Re: **BOB's Burger**
305 Eubank Blvd NE
Traffic Circulation Layout
Architect's Stamp 05-17-2022 (K20-D049)

Based upon the information provided in your submittal received 05-17-2022, the above referenced plan cannot be approved for Building Permit until the following comments are addressed:

SHEET TITLE  
Traffic Control  
Layout

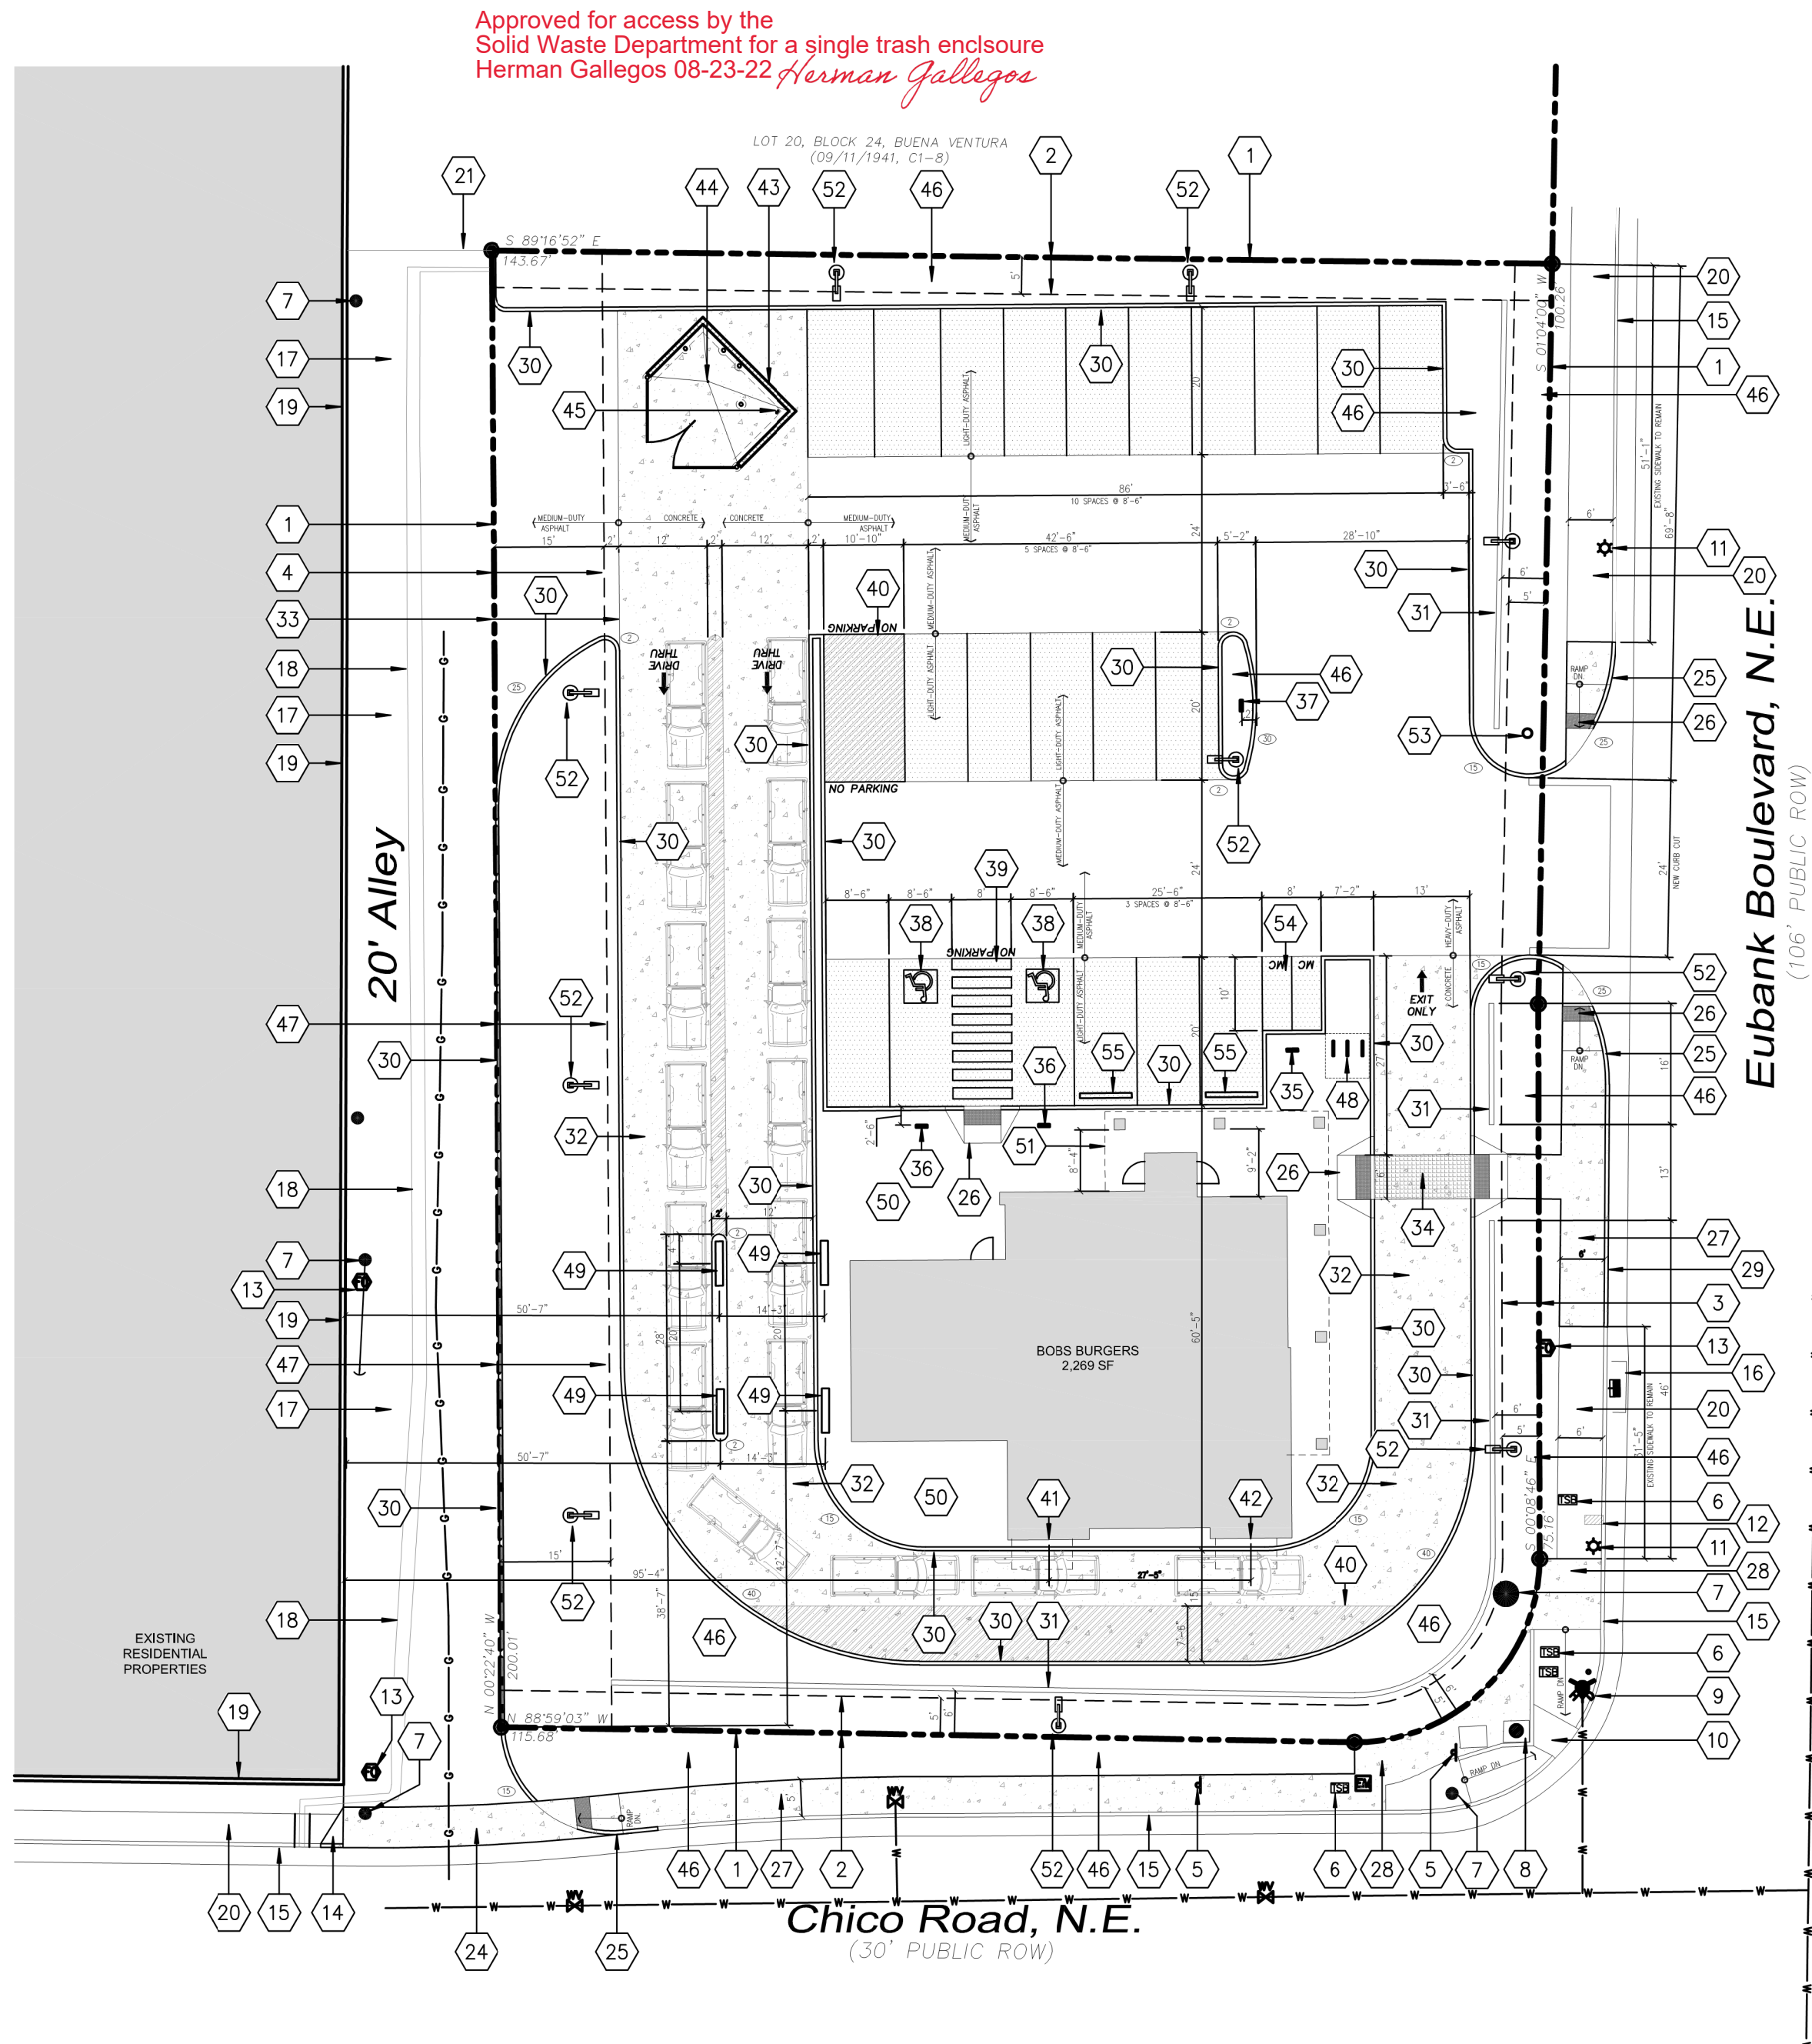
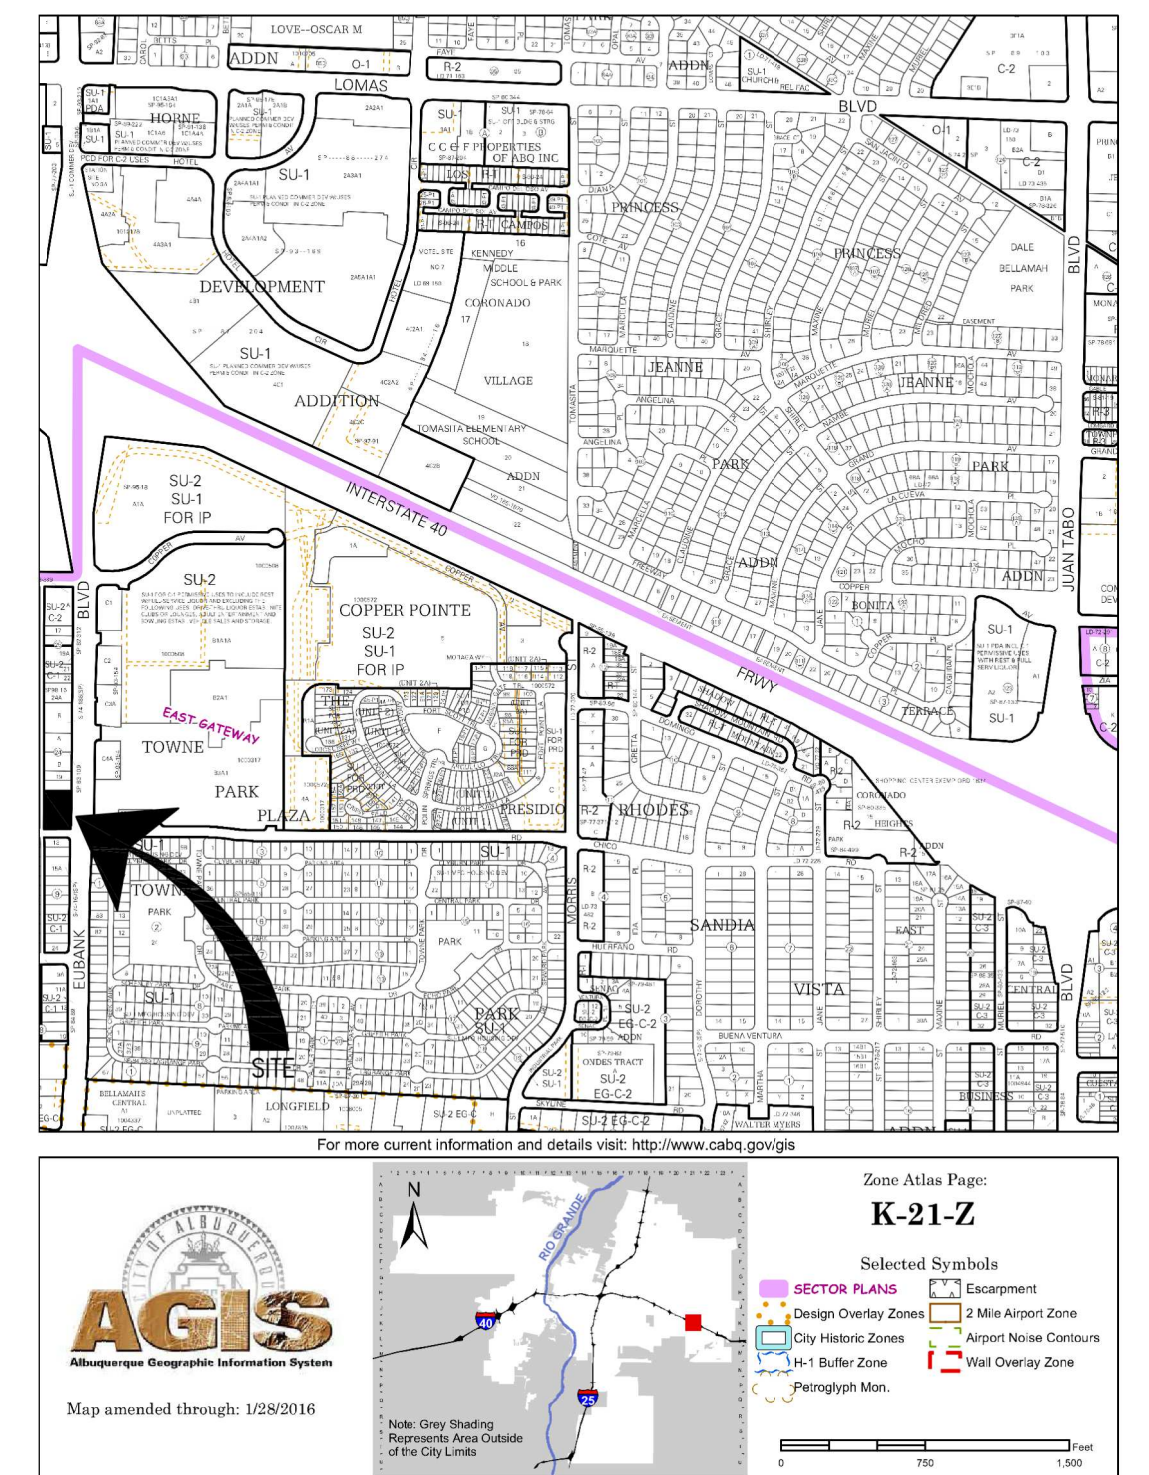
1. Listed are the number of parking spaces(**ADA stalls ?**) required by the IDO as well as the proposed number of parking spaces including bicycle and motorcycle parking.
Coordinate/discuss with Zoning.
2. Proposed driveway entrance off Eubank Blvd: Please call out COA std dwg 2426 (this will include 6 ft valley gutt and unidirectional ramps) for details.
3. **Keyed Note 20:**
 - Why are you proposing this at northern end of Alley way?
 - Provide Alley way width.
4. **Keyed Note 24, 27, 29, 30, 35, 36, 39, & 40:** Details will need to be provided and/or referenced COA std dwg on some.
5. **Keyed Note 33:** The will function appropriately on private property but not on Alley Way. Provide note to ensure this concern unless it is on Alley (**then a Work Order will be required**)
6. **The minimum parking stall dimensions are (Some are not shown):**

7. The ADA accessible spaces must include an access aisle. **Van accessible aisles should be 8ft wide**; all others should be 5ft wide.

8. The ADA accessible parking sign must have the required language per 66-7-352.4C NMSA 1978 **"Violators Are Subject to a Fine and/or Towing."** Please call out detail and location of signs.

9. The ADA access aisles shall have the words **"NO PARKING"** in capital letters, each of which shall be at least one foot high and at least two inches wide, placed at the rear of the parking space so as to be close to where an adjacent vehicle's rear tire would be placed. (66-1-4.1.B NMSA 1978)

10. ADA curb ramps:
 - **Eubank/Chico:** Corner ramp must be current/updated design and have truncated domes installed for public ramps.
 - Must be updated to current standards. and have truncated domes installed for public ramps and details must be provided for each type of proposed ramp.

- **Keyed Note 14 & 28:** You will need a full detail of ramp to include dimensions and concrete design and slopes.
11. **Chico drivepad:**
 - Provide details for all proposed infrastructure on plans.

- A special detail will be needed for drivepad transitioning from pad to curb returns (from a gutter pan to a 6 ft valley gutter).
 - Locate proposed sidewalk segment to property line and not at back of curb as shown.

- You will need adjacent property owner permission to perform work on his frontage. Provide letter of permission.
 - Call out COA std dwg 2430 for Keyed Note 27.

12. **Motorcycle parking spaces:** Spaces shall be designated by its own conspicuously posted upright sign, either free-standing or wall mounted per the zoning code. Label pavement MC (provide pavement markings-text details).

16. Bicycle parking spaces shall be at least 6 feet long and 2 feet wide.
17. Minimum radii's will need to be 15'R. Adjust site plan to reflect this concern..

18. Per the DPM, a 6 ft. wide ADA accessible pedestrian pathway is required from the public sidewalk to the building entrances. Please clearly show this pathway and provide details.

19. Per DPM, a 6 ft. wide ADA accessible pedestrian pathway is required from the ADA parking stall access aisles to the building entrances. Please clearly show this pathway and provide details.

20. All sidewalks along **public streets** should be placed at the property line.
21. Curbing should be installed to delineate landscape, parking, and pedestrian ways and identify points of access. Please call out detail and location of barrier curb.

26. All one-way drives shall have "One Way" and "Do Not Enter" signage and pavement markings. Please **show detail and location of posted signs and striping (Includes pavement markings and proposed texts).**

27. **Drive Thru Lane:**
 - Provide a queuing analysis to ensure storage lane will not stack into public streets **(IF APPLICABLE)**.
 - The minimum drive through lane width is 12 feet with a 25 foot minimum radius (inside edge) for all turns. (A 15 foot radius can be used with an increase in lane width to 14 feet). Please dimension all lane widths and radii.

28. All proposed pavement markings, striping, arrows will need details shown on Site Plan.
29. Please provide a sight distance exhibit
30. Show the clear sight triangle and add the following note to the plan: "Landscaping and signage will not interfere with clear sight requirements. Therefore, signs, walls, trees, and shrubbery between 3 and 8 feet tall (as measured from the gutter pan) will not be acceptable in the clear sight triangle.
